From: [Alisa Nicholson](#)
To: [Emily Dickson](#)
Cc: [David M Zabell](#)
Subject: City of Sydney to DPIE - response to SEARs - SSD 10362 - R/2019/10
Date: Friday, 9 August 2019 7:06:49 PM
Attachments: [image002.png](#)
[City of Sydney to DPIE - response to SEARs - SSD-10362 - R-2019-10.pdf](#)
[Documentation - Draft SEARs - SSD 10362 - R201910.DOCX](#)
[Hans Group to DPIE - Request for Delegation - 338 Pitt Street, Sydney - SSD 10362.PDF](#)
[Plan - Inconsistency between approved tower envelope and proposed towers - R 2019 10.PDF](#)

File No: 2019/382263

Our Ref: R/2019/10

Request for SEARs - 330-338 Pitt Street, 241-253 Castlereagh Street and 126-130 Liverpool Street Sydney - New mixed use two-tower development with basement excavation - SSD 10362

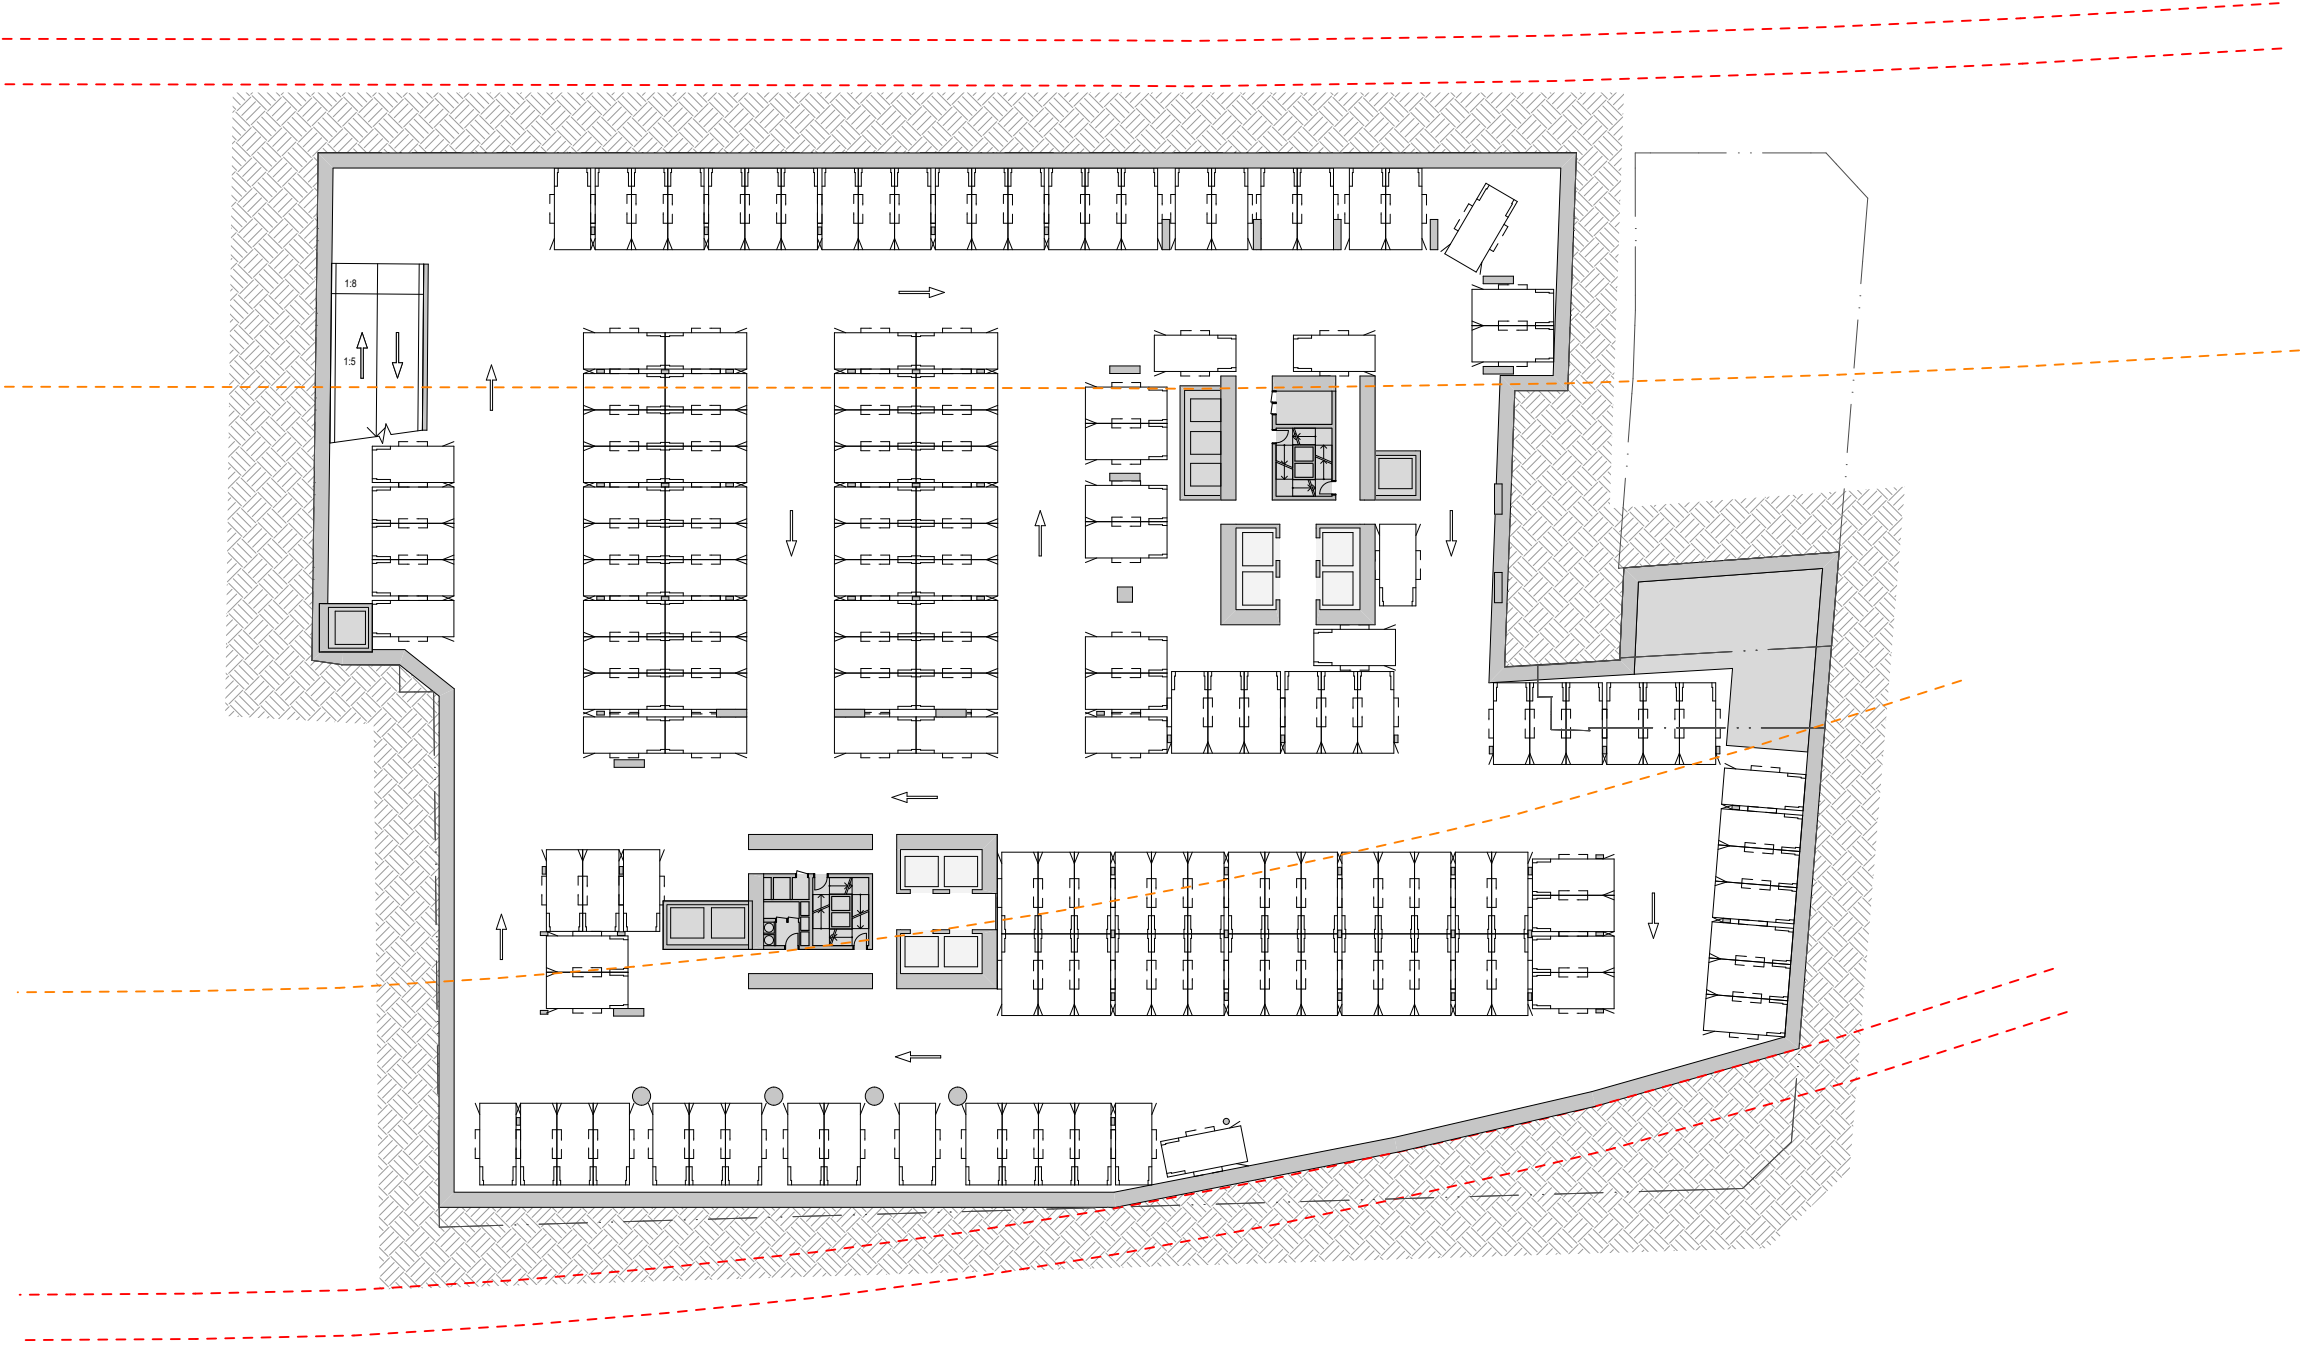
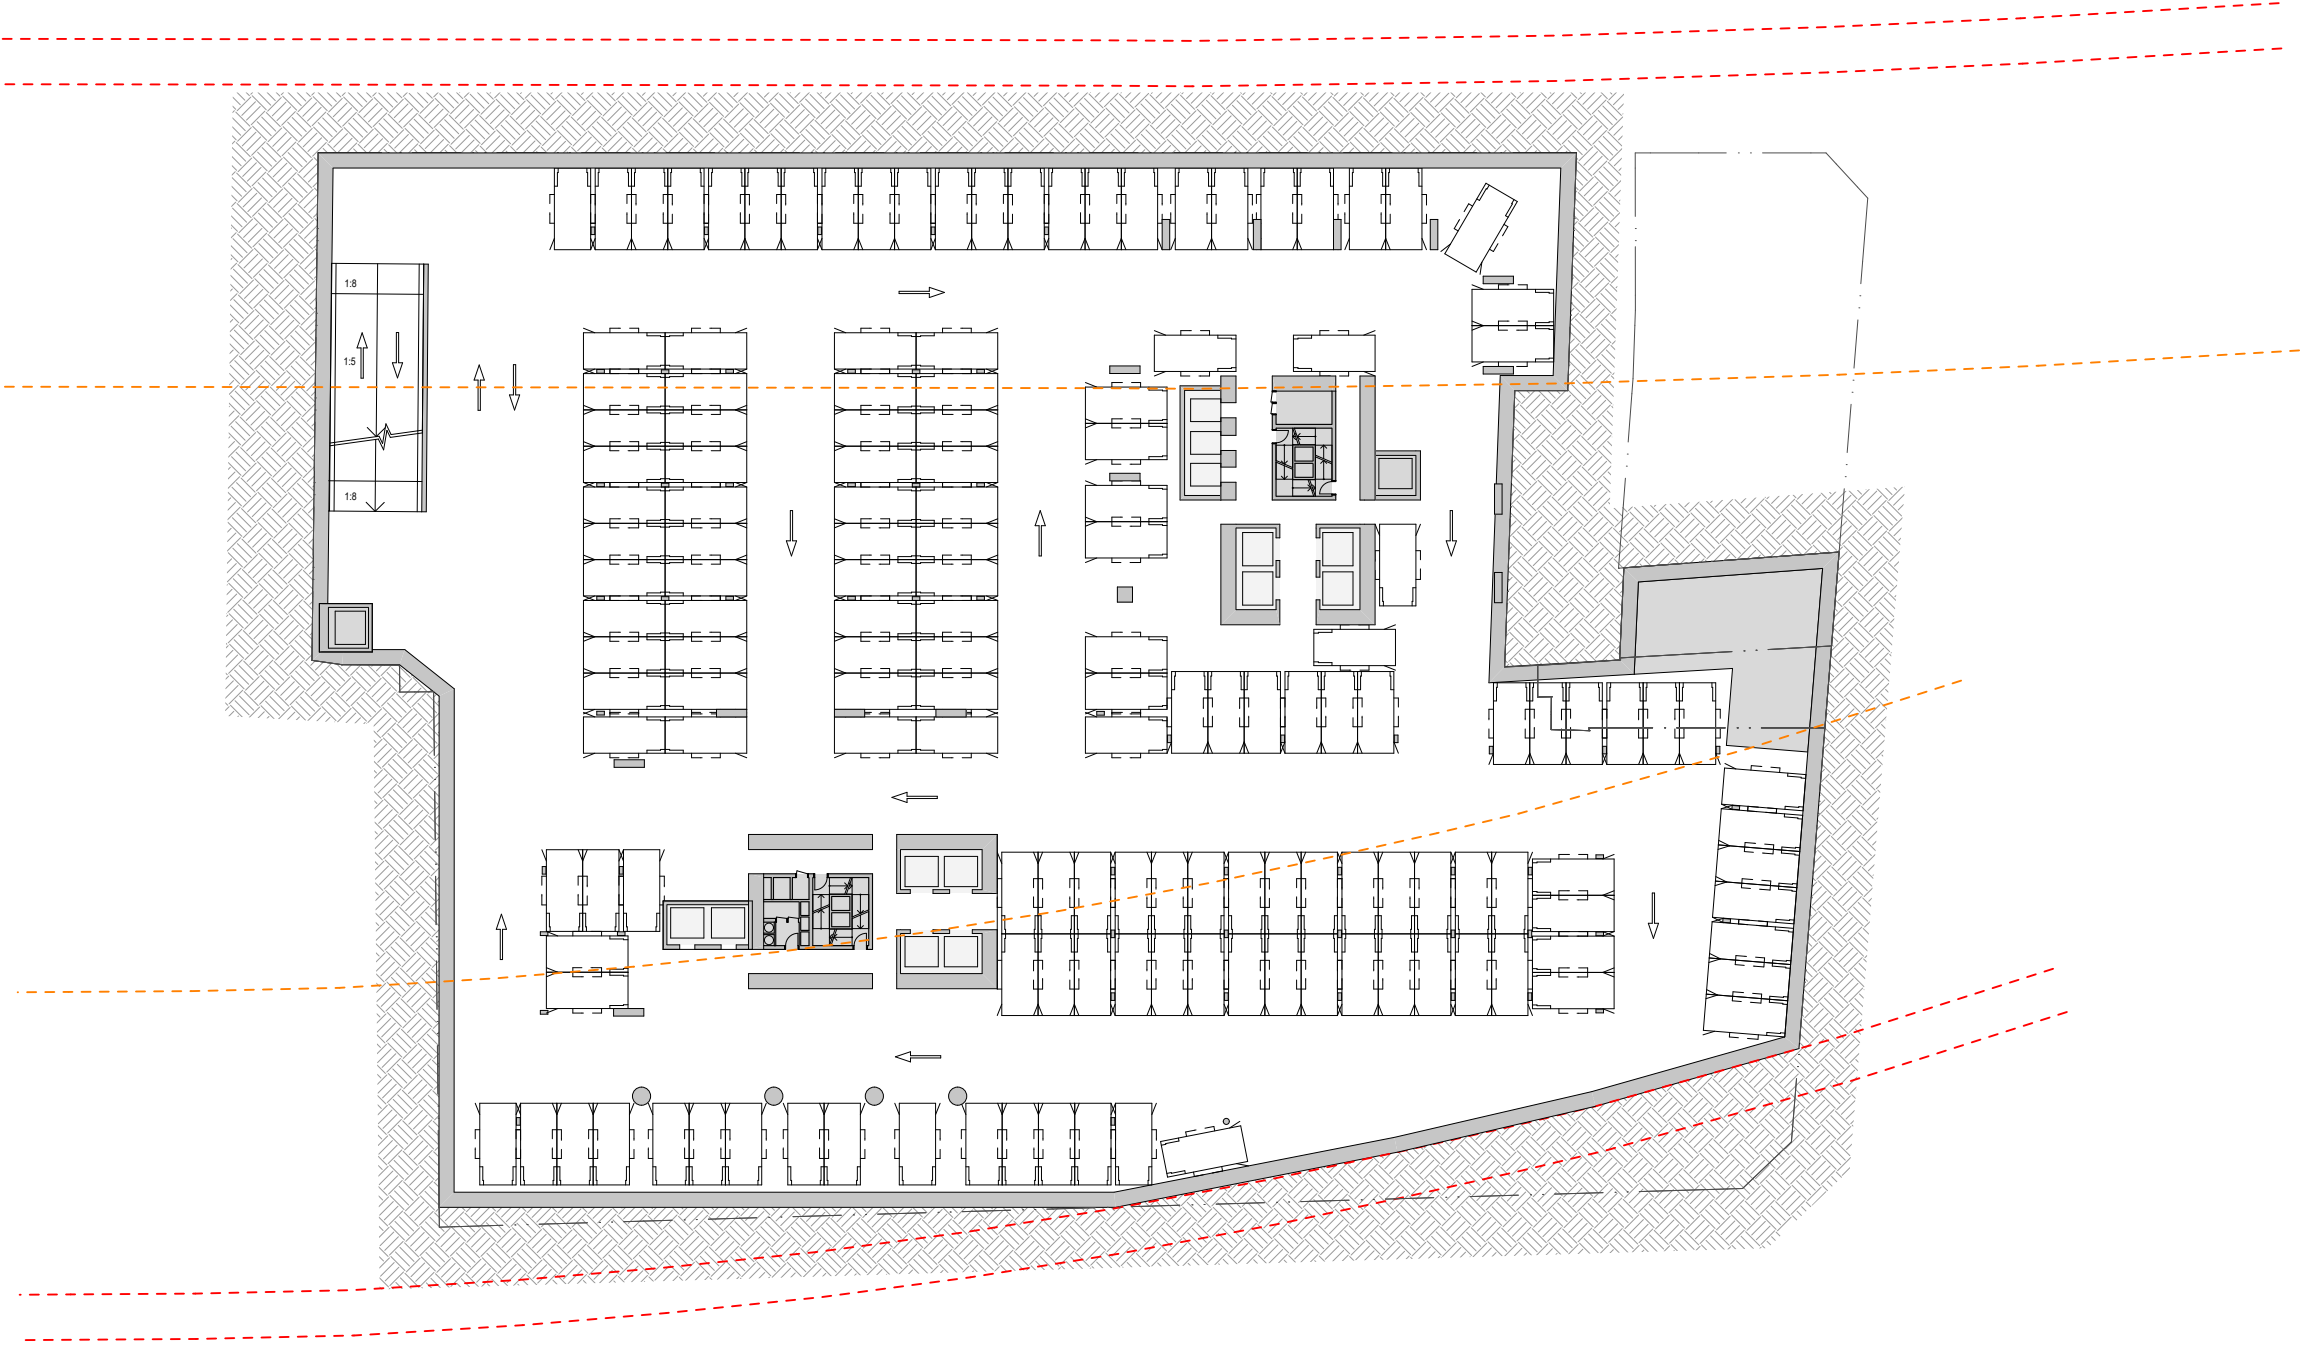
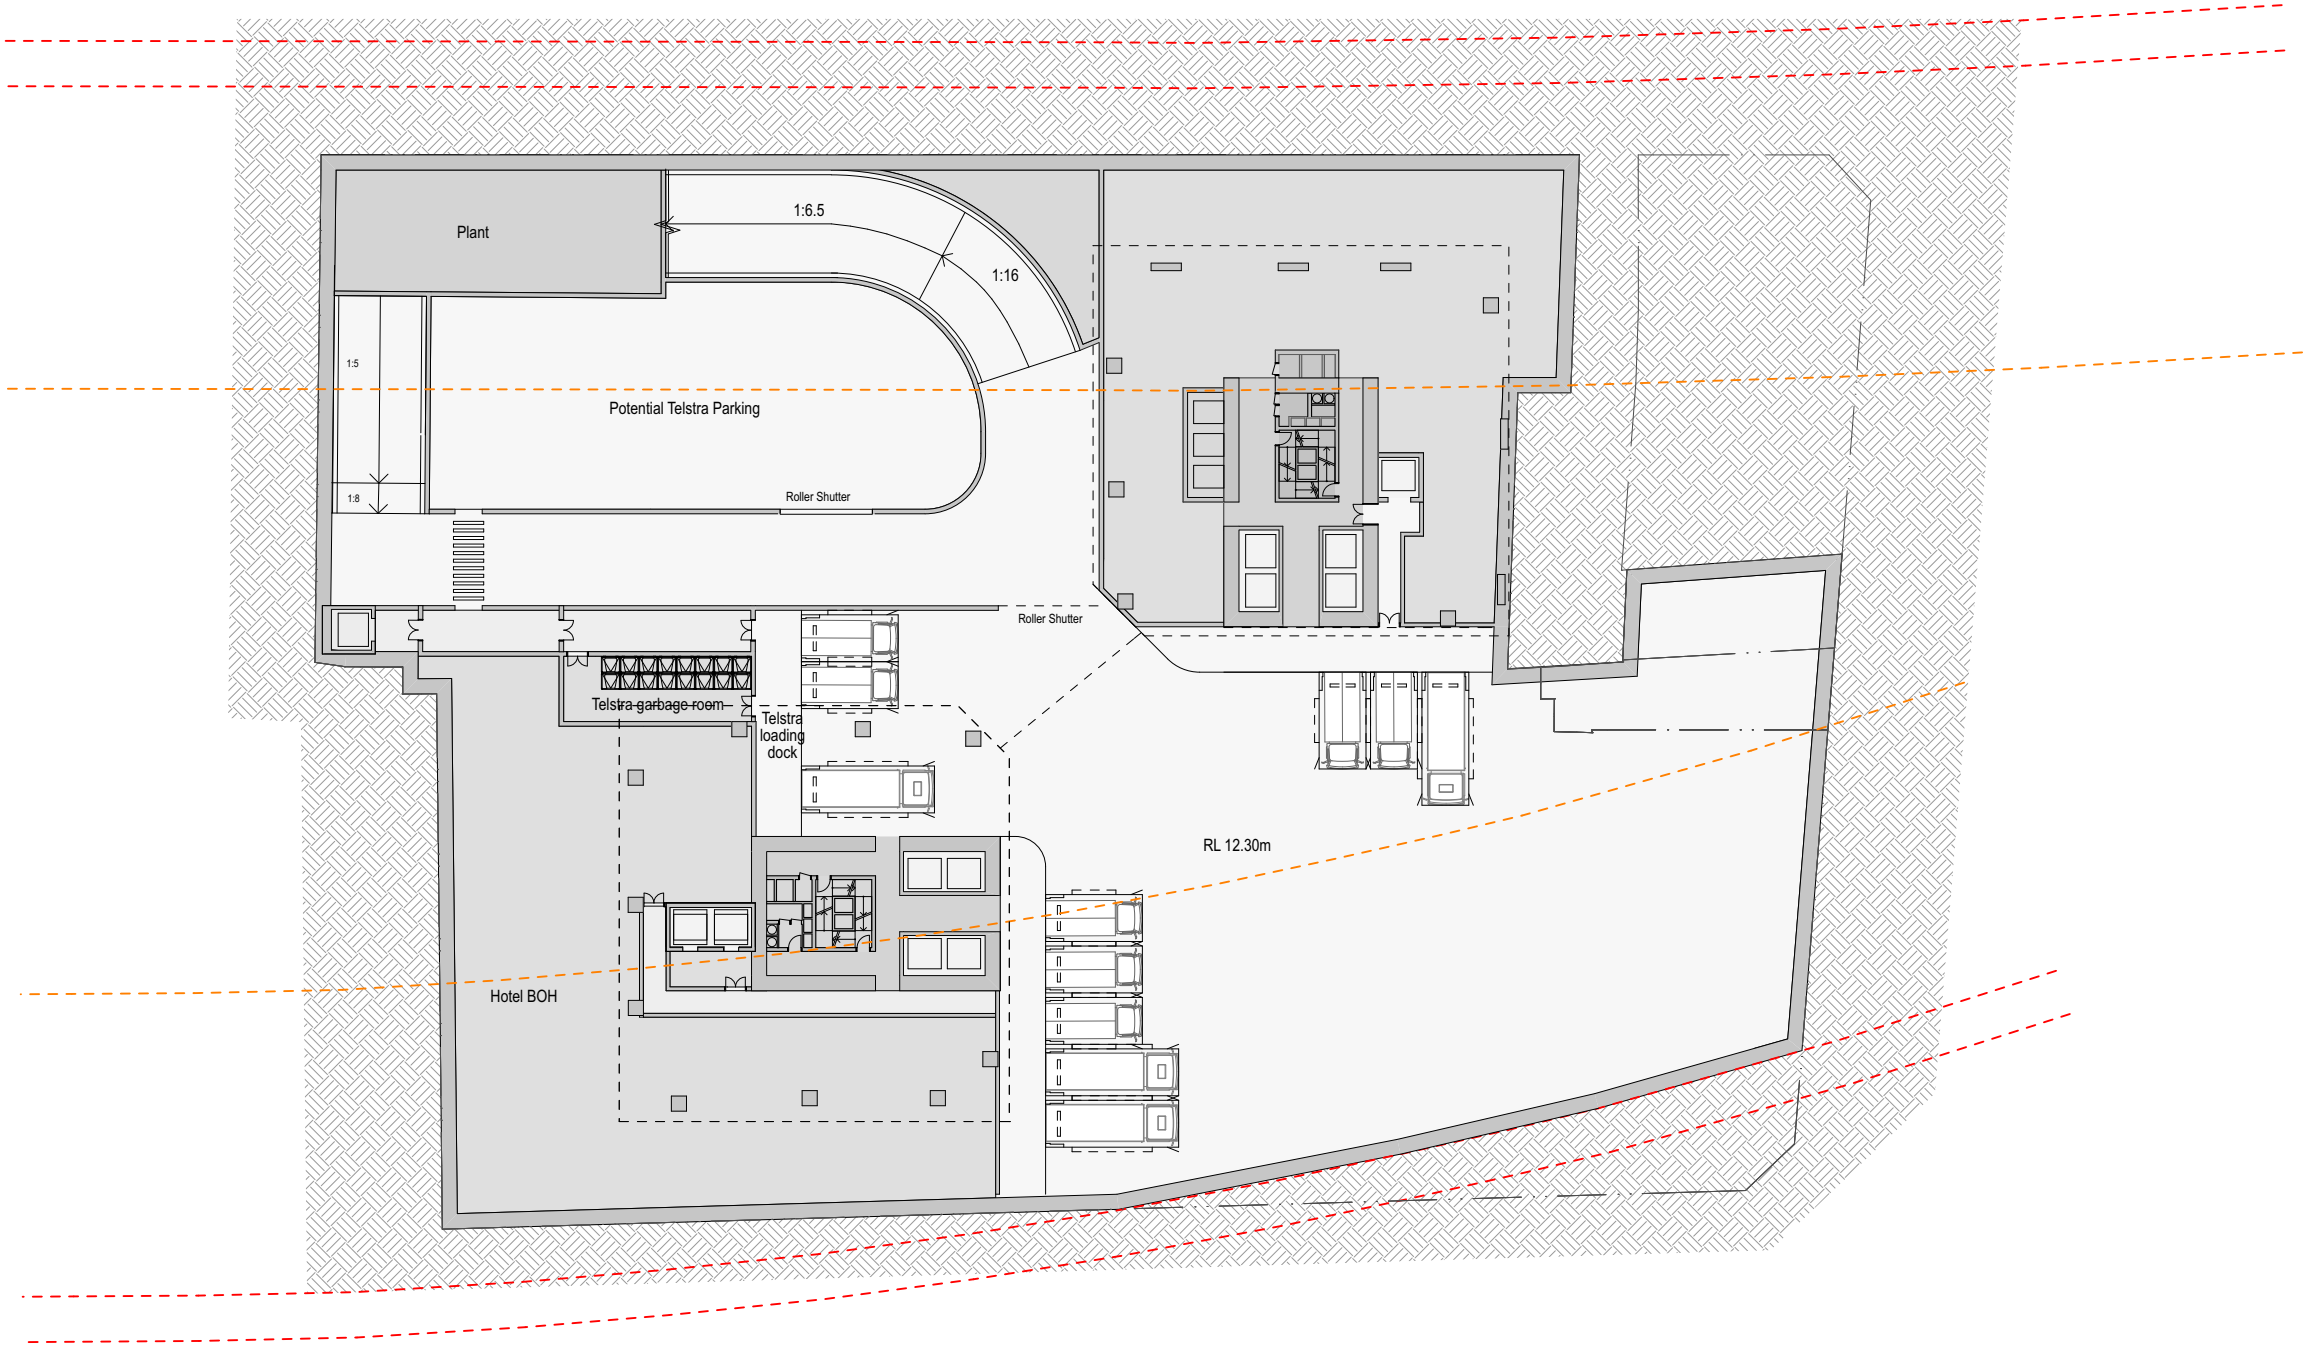
- The proposed towers extend laterally beyond the approved building envelope (see attached).
- Residential floor space is proposed below level 10 contrary to condition 10.
- The towers exceed the lowest maximum height of 276.5 metres on the southwest corner (including the 10% design excellence bonus).

In accordance with Section 4.24(2) of the *Environmental Planning and Assessment Act 1979* ("the Act"), the application must not be inconsistent the concept approval. As such, these matters will be addressed by City staff during the assessment of the application.
